Your Ref: OWPC16799
Our Ref: BR/194/17/PL 30-06-2017
Please ask for:
Richard Temple

Demolition of the existing Foreshore office & decommissioning of existing underground toilets. New purpose built unisex toilet block including urinals, baby changing facilities & accessible WC, plus a separate beach office with public information point & first aid facilities. All located on the existing seafront promenade.

Promenade Opposite Walton Avenue The Esplanade Bognor Regis

DRAWING
Proposed Toilet Elevations

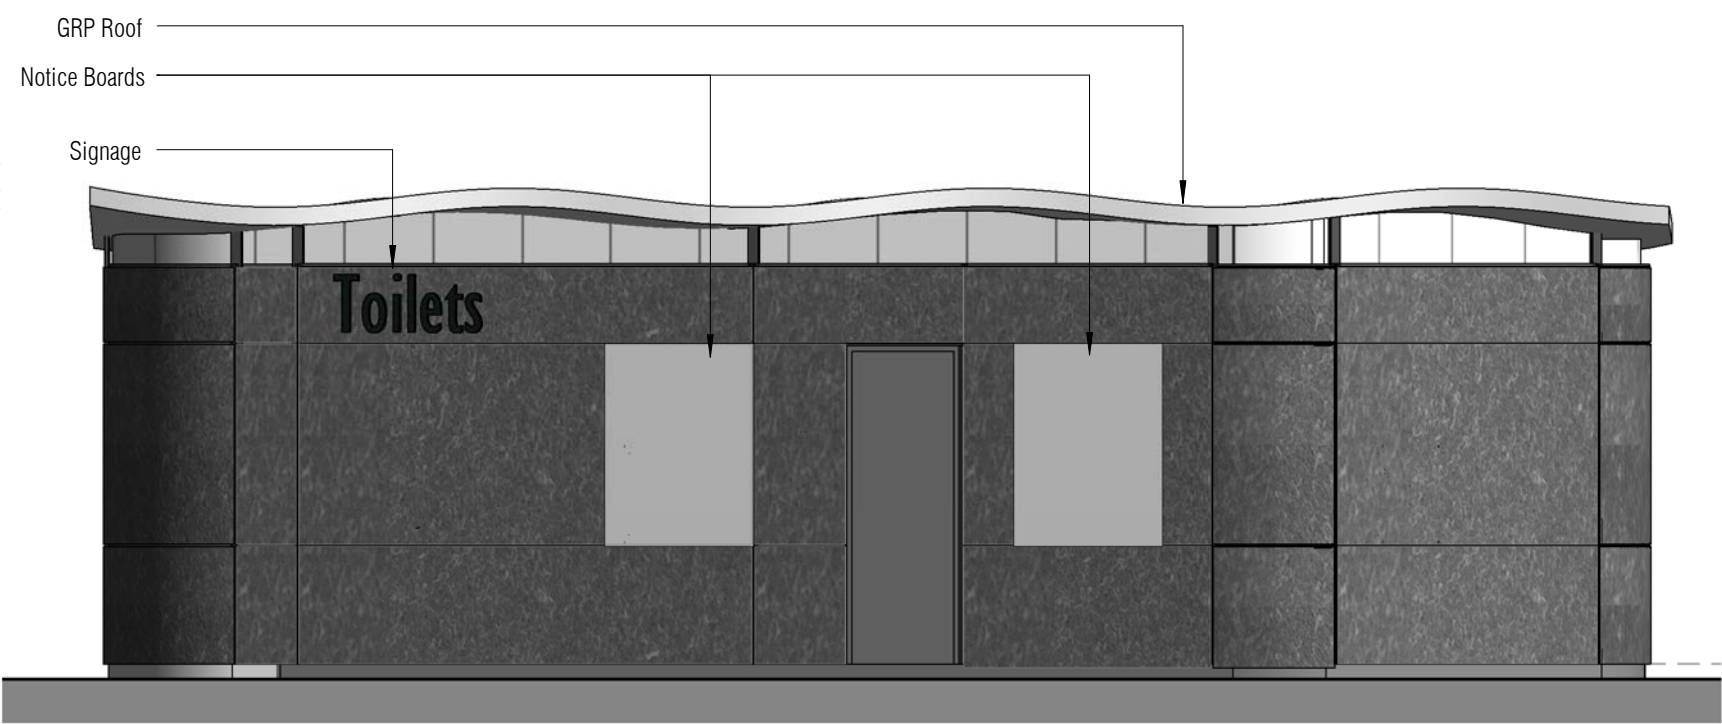
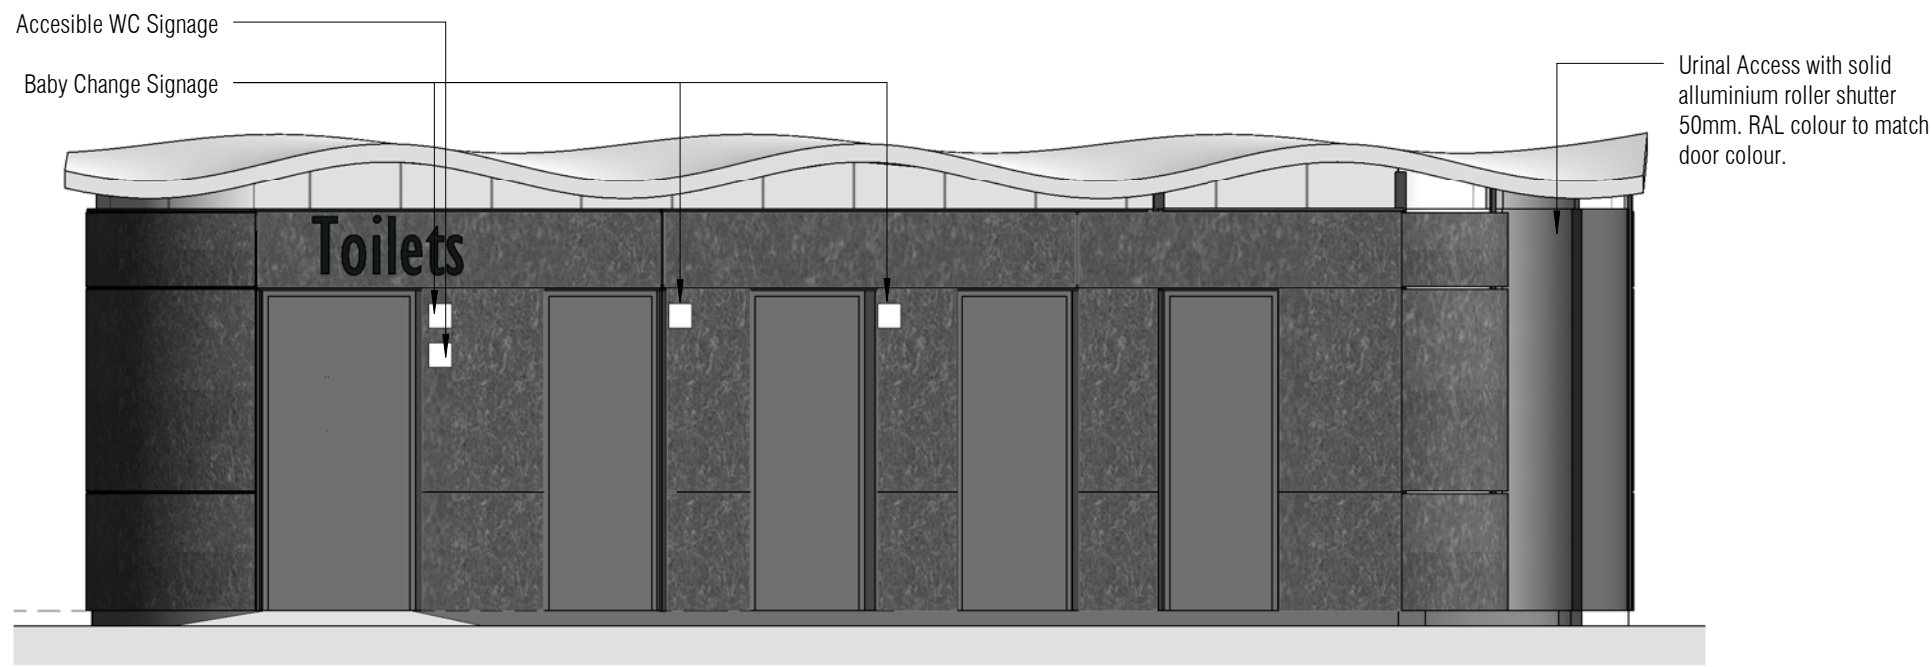
The revised proposal, having the cubicle doors on the south side, is an improvement on the original. However, the proposed signage would be unnecessarily disproportional, odious, and aggravating to residents opposite. Moderate signage at each end of the toilet block would be sufficient.
